Letter No. **L1/13975/93**

Sub: MMDA - Planning Permission - *Sub-Division*
**Layout of house sites in S.No.332/30pt.
of Selaiyur Village - Approved -
Regarding.**

TAMBARAM MUNICIPALITY
 SUB-DIVISION OF HOUSE SITES IN S. NO. 332/3C PT, (332/3A3CAS PER PATTI) OF
 SELAIYUR VILLAGE.
 SCALE: 33 FEET TO AN INCH.

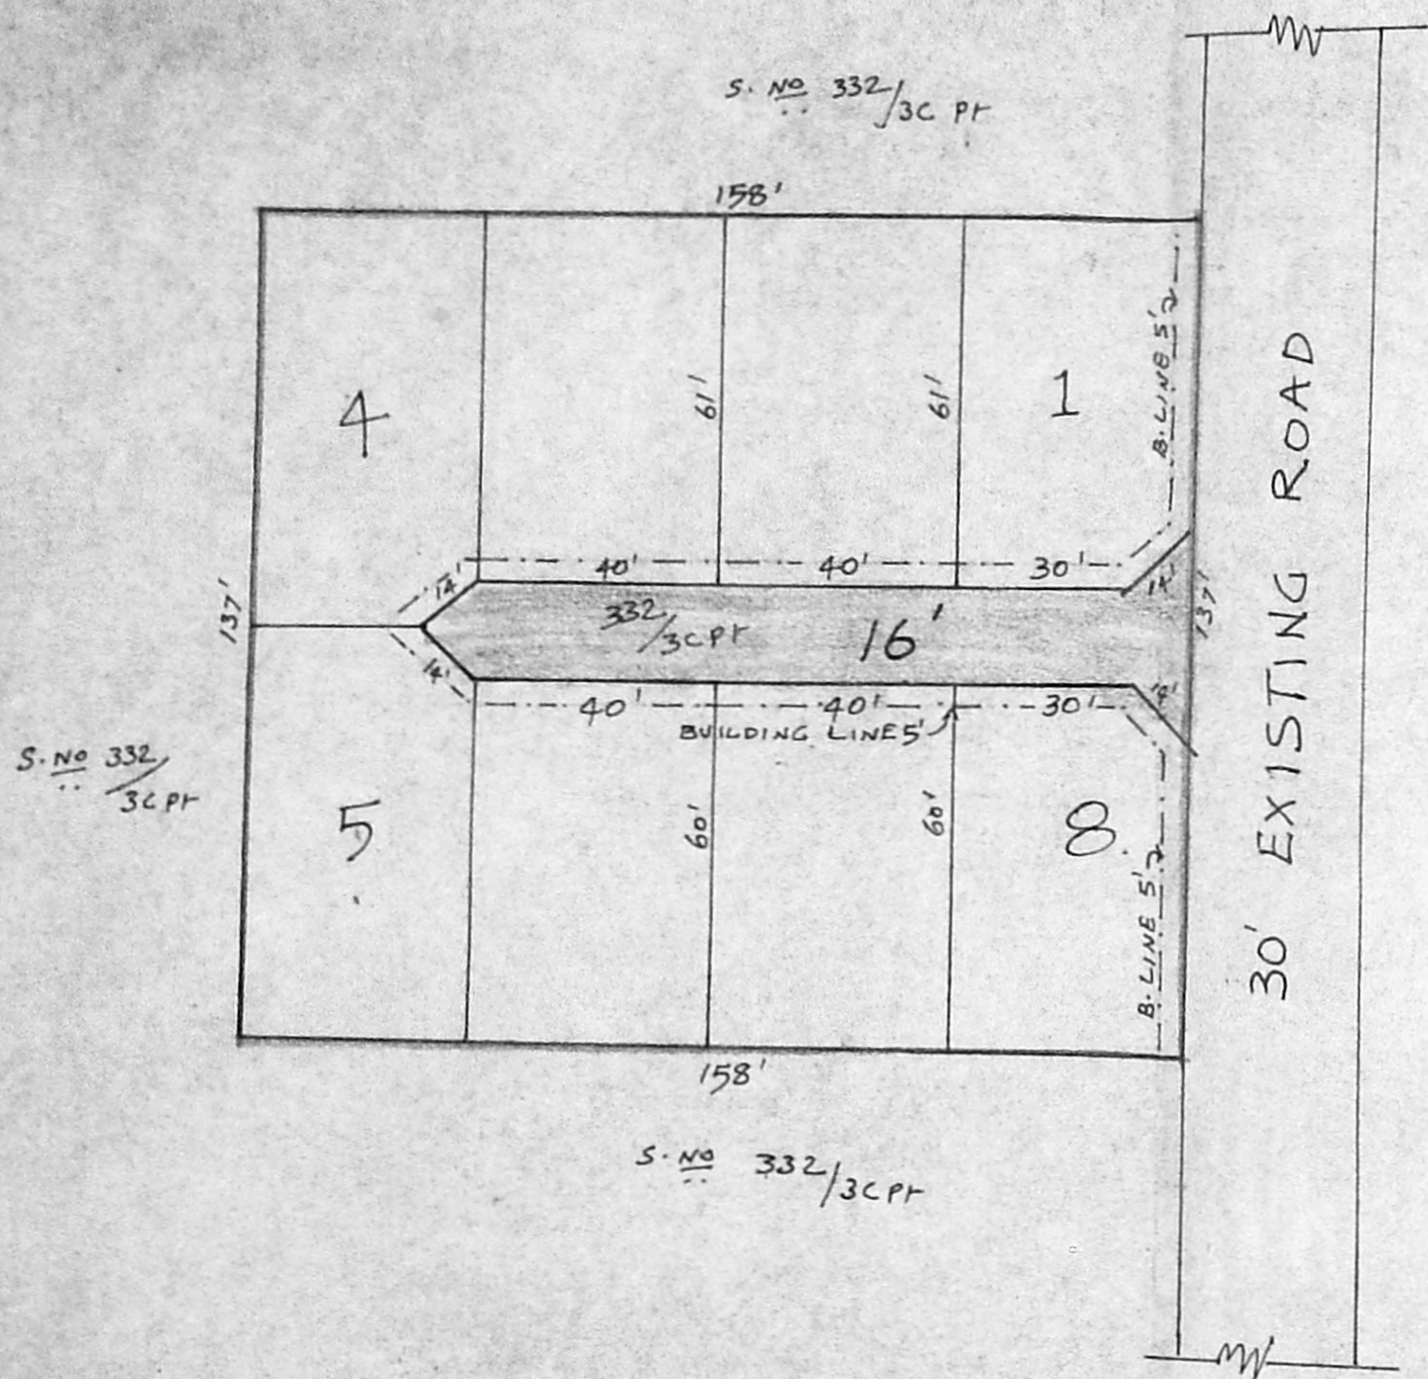
The proposal received in the reference cited for sub-division house sites in Survey No.332/30pt. of Selaiyur Village was examined and Sub-division plan has been revised to satisfy the Development Control Rule requirements and approved, subject to the condition that No structure exceeding 20 feet (6.1m.) in height shall be constructed in these plots and the 16 feet passage shown in the plan remain private.
